SCOPING OPINION:

Proposed South Brooks Solar Farm

Case Reference: EN0110027

18 December 2025

Drawing number	Revision
Figure 2.1	01

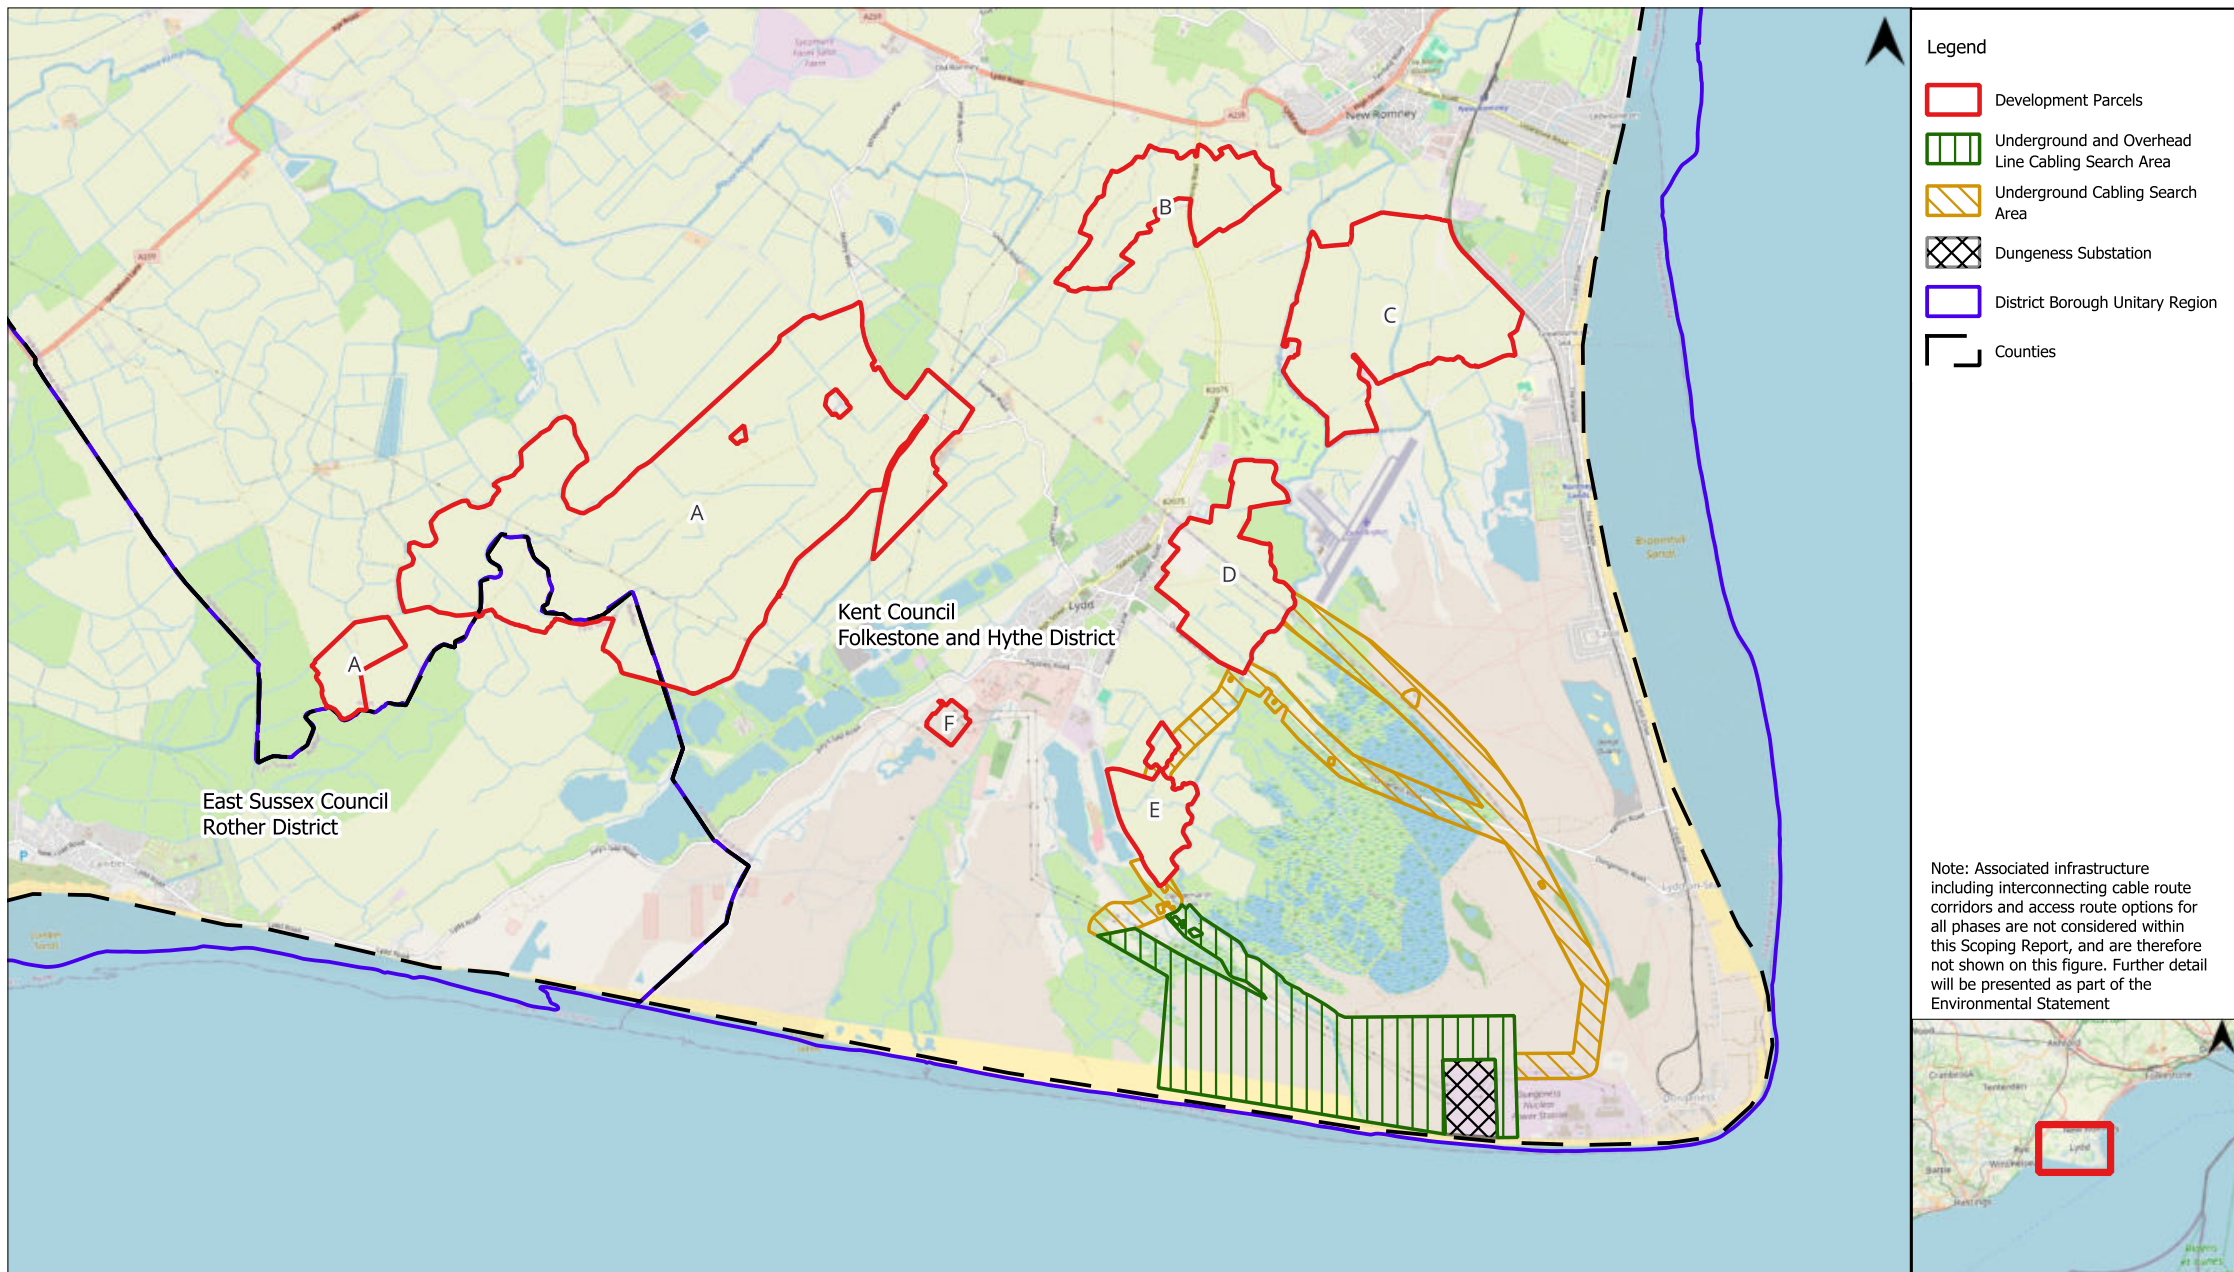
213	Figures 2.0 and 2.1, Paragraph 2.1.2	Baseline characterisation	Scoping Report paragraph 3.3.1 refers to the site boundary as parcels A to F of the proposed development site. This excludes the cable route search area identified on figure 2.1. The baselines throughout the Scoping Report are characterised for the site boundary area and exclude the cable route search area. Baselines presented in the ES should be characterised for the entirety of the proposed development and red line boundary. The

ID	Ref	Description	Inspectorate's comments
			methodology for characterising the baseline should be explained, and agreement should be sought on the approach with the relevant consultation bodies.
214	Figure 2.1	Parcel A	The Inspectorate notes that there are two parcels of land named 'Parcel A' on the Scoping Report figures. It is currently assumed that when the Scoping Report refers to 'Parcel A' it is referring to both sites, however, the ES should explain why two parcels are considered as one and ensure that there is clarity around which areas of land are being referred to throughout the ES.
215	Paragraph 3.3.1	Potential changes in red line boundary after scoping	Scoping Report paragraph 3.3.1 states that the proposed development site may be 'subject to change' as the design and EIA progress, and that figure 2.0 represents the 'current' land which could form the proposed development. It is not clear if this refers to the refinement of the red line boundary within the current boundary or the potential to extend the red line boundary after scoping. If the red line boundary extends beyond the red line boundary presented in figure 2.0 then the applicant should consider whether all the comments in the Scoping Opinion remain applicable or whether this represents a materially different project. The Inspectorate expects that at the point an application is made, the description of the proposed development will be sufficiently detailed to include the design, size, capacity, technology, and locations of its different elements. Where details are not yet known, the assumptions applied to the impact assessment in relation to these aspects should also be set out. Where flexibility is sought, the ES should clearly set out and justify the maximum design parameters that would apply for each option assessed and how these have been used to inform an adequate assessment. The applicant should nevertheless make every attempt to narrow the range of options within the ES, explain clearly which elements of the proposed development have yet to be finalised and provide the reasons. At the time of application, any proposed development parameters should not be so wide-ranging as to represent effectively different developments. It should be noted that if the proposed development materially changes
